DRB Application No.: 06DRB-00570(P&F)

Project # 1003212

Project Name BROWNEWELL & LAILS
HIGHLAND ADDITION

06DRB-00569 Major-Vacation of Public Easements
 06DRB-00570 Minor-Prelim&Final Plat Approval

PLAT OF
TRACT A-1-A-1-A, BLOCK 34
 AND
TRACT B-1-A, BLOCK 33
BROWNEWELL & LAIL'S
HIGHLAND ADDITION

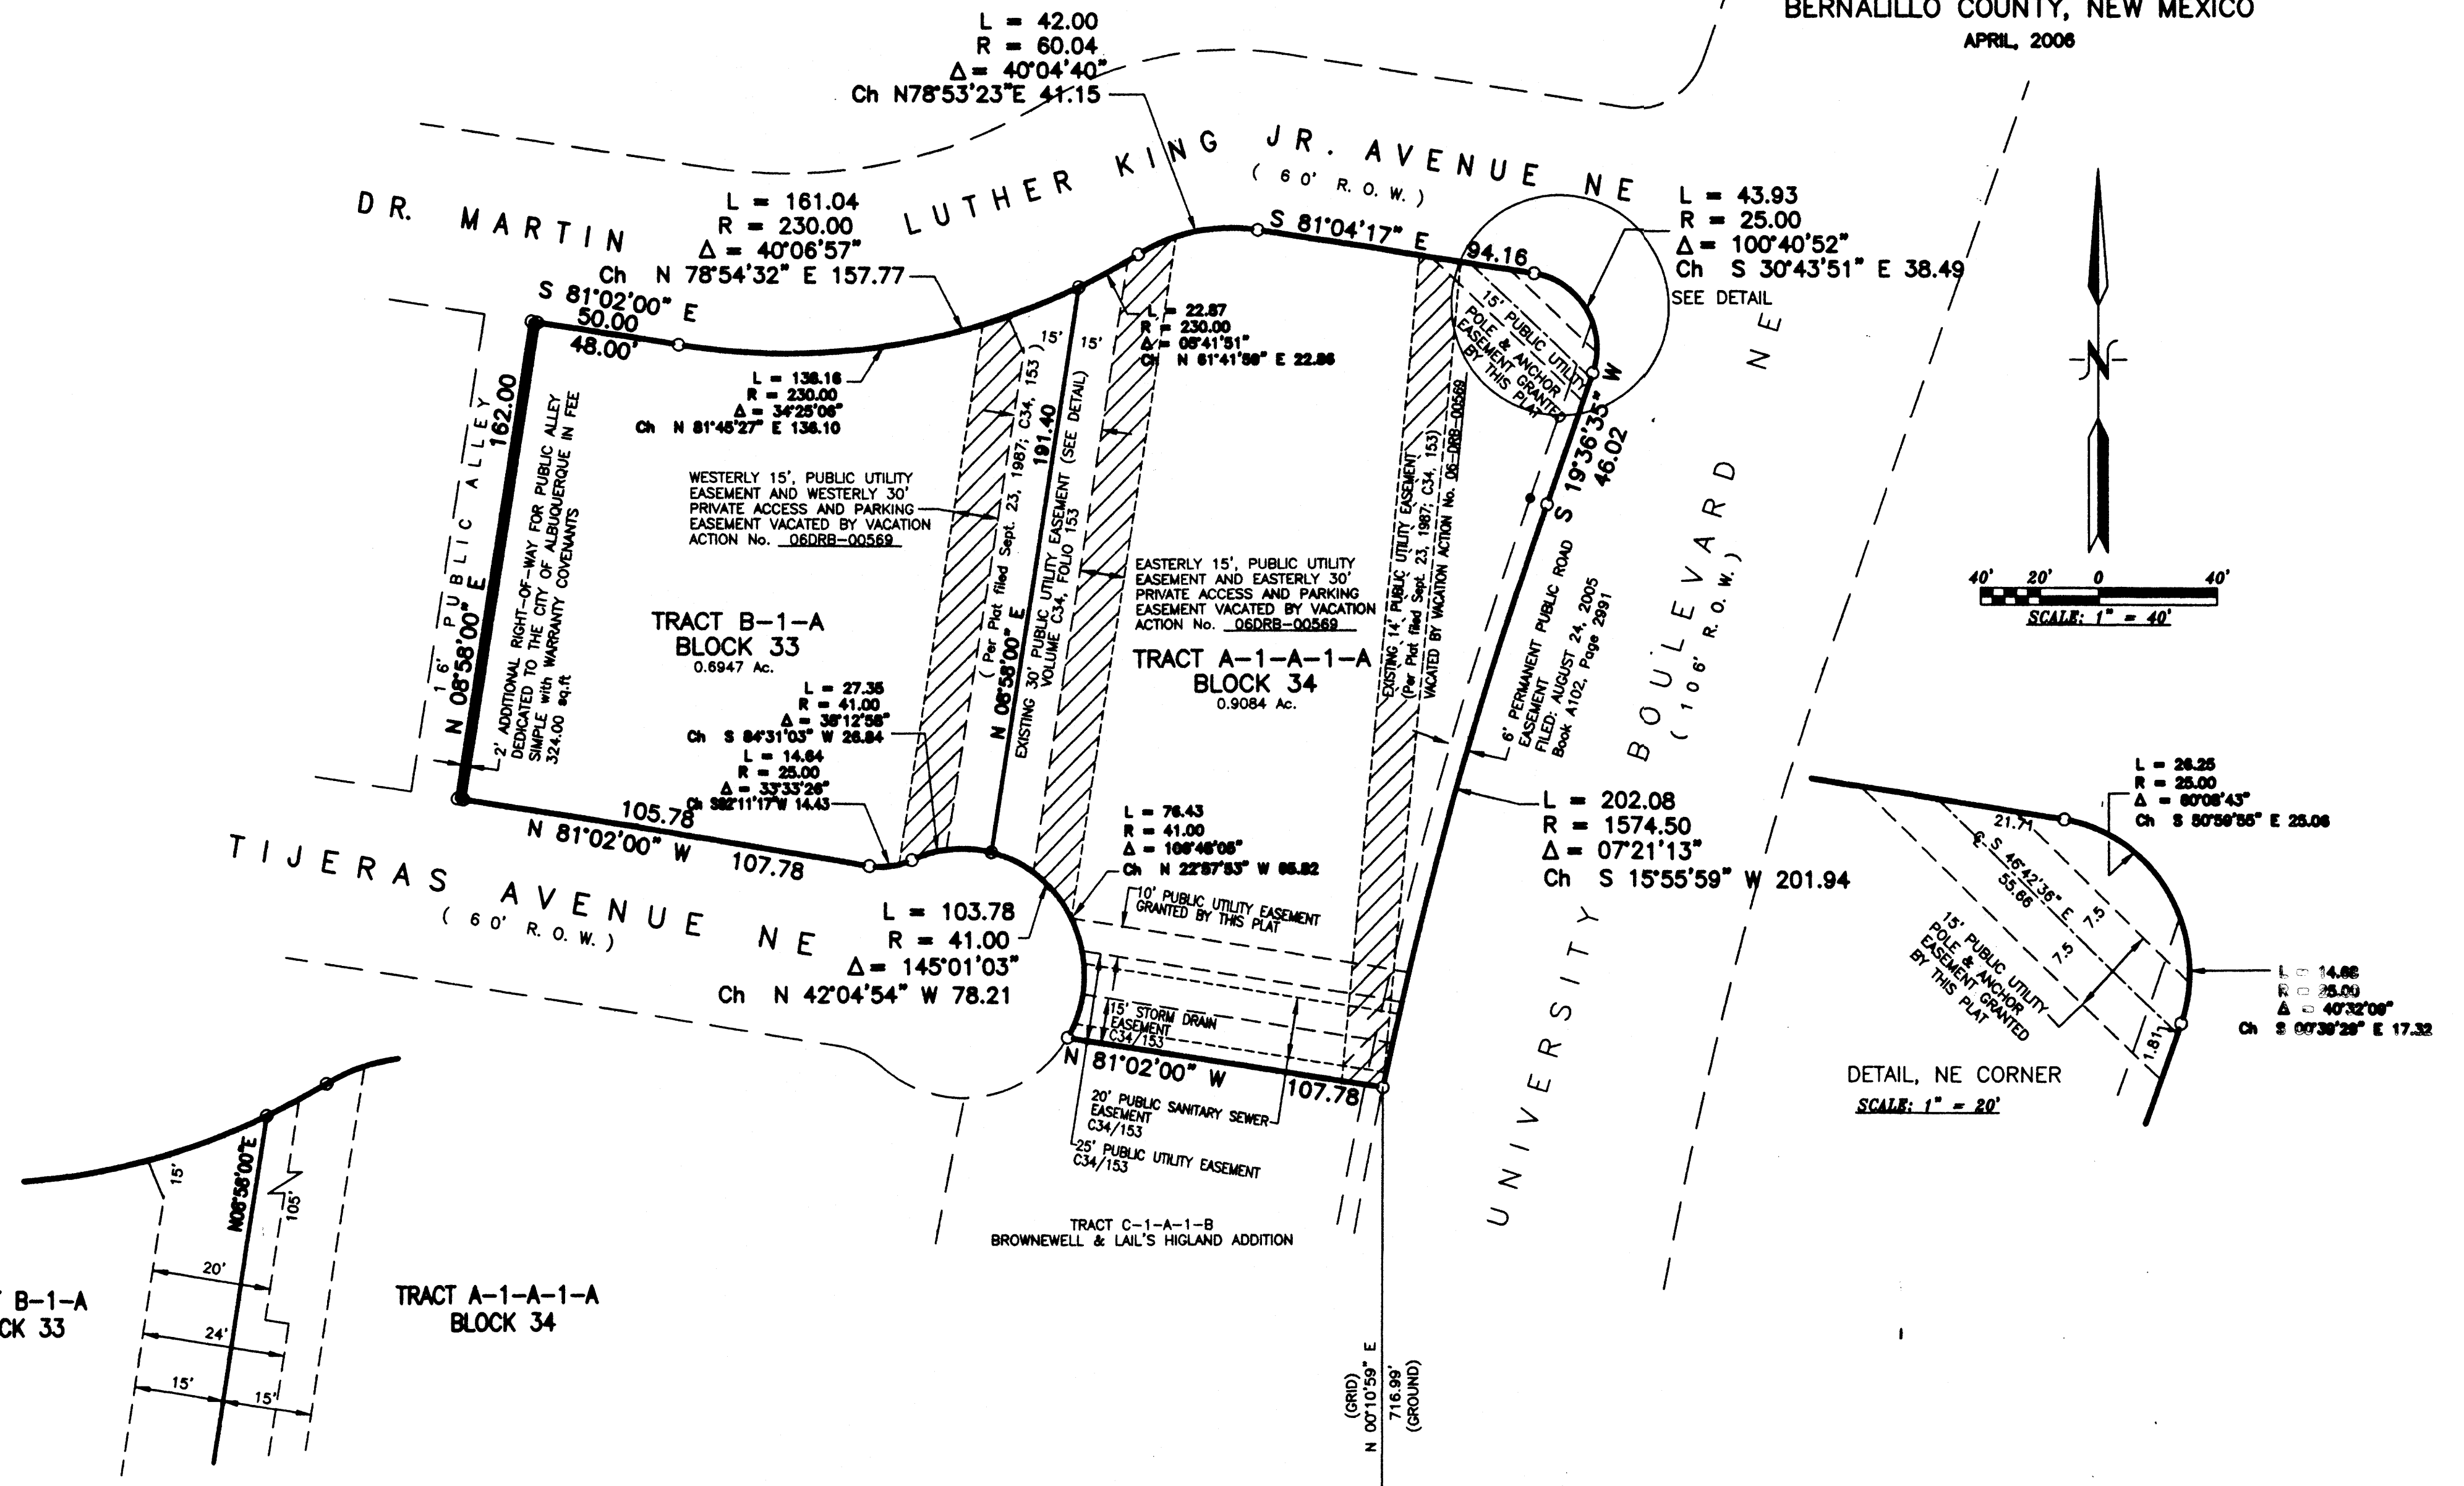
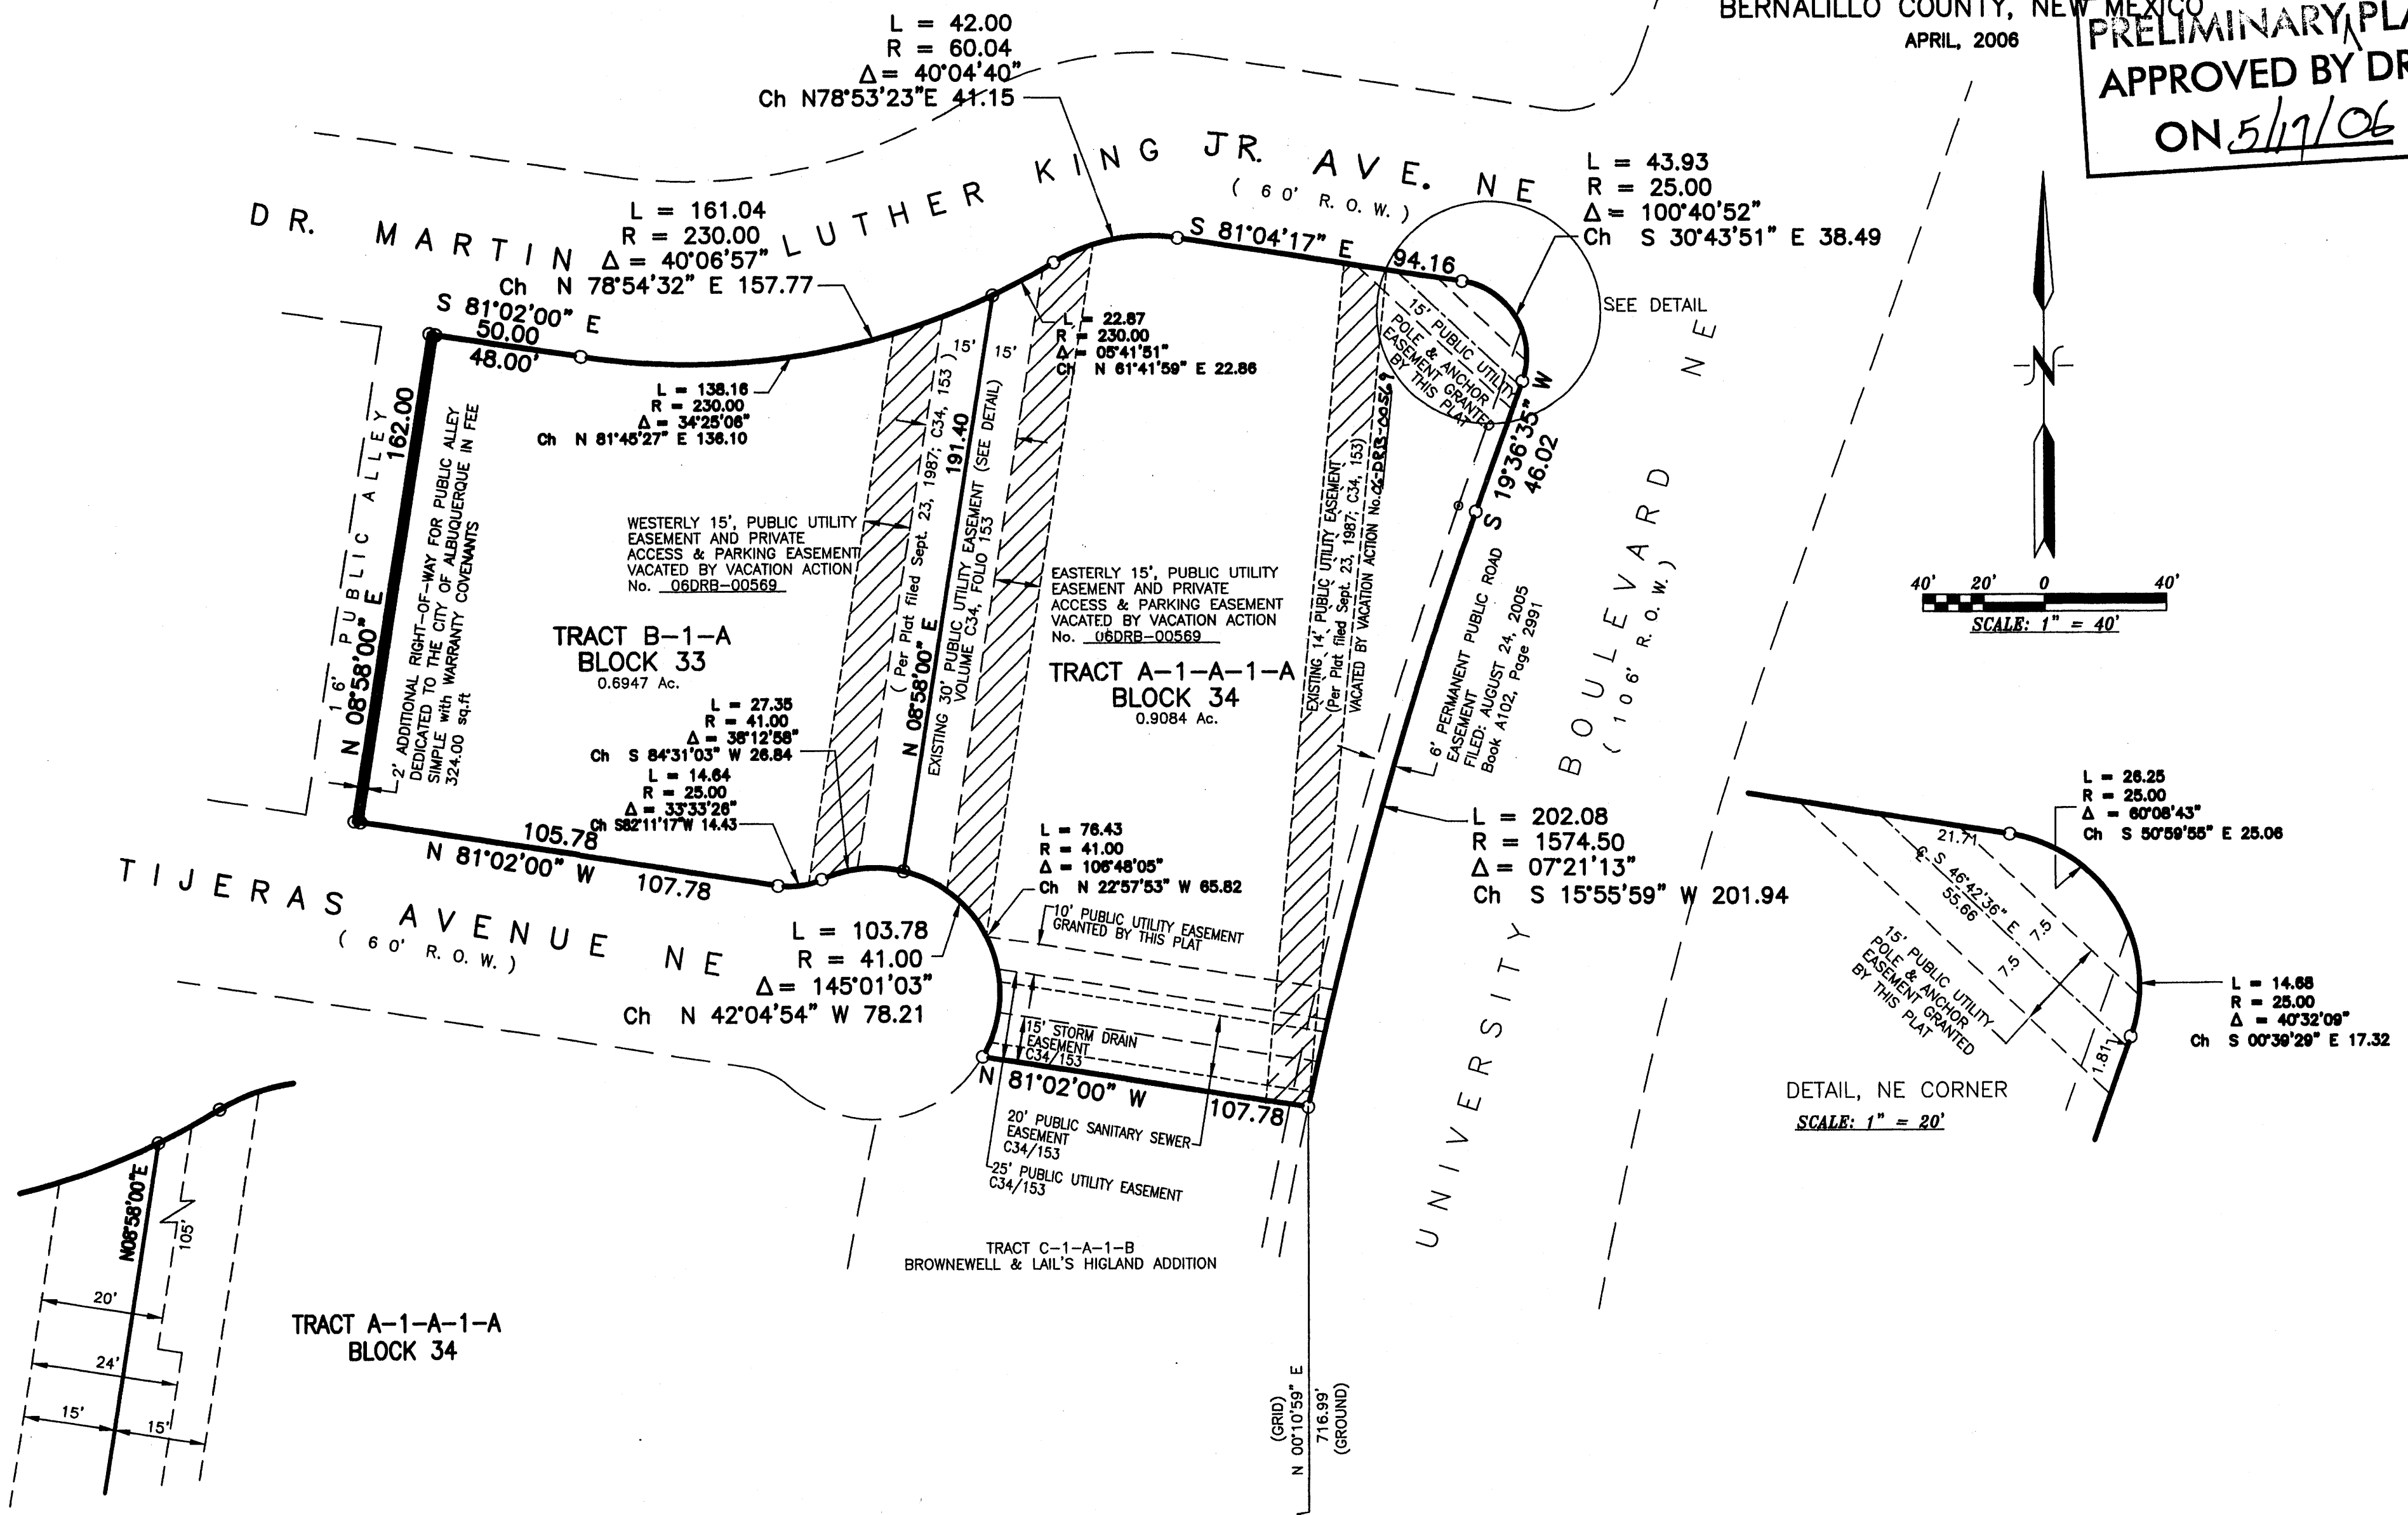
TRANSPORTATION: Clarification of parking and access
easement.

No objection to the vacation request. Easements on south side of plat need clarification.

No objection to the vacation requests. Why doesn't the access easement bend to cover the new drivepad from MLK? Why is there only 20' along the northern portion?
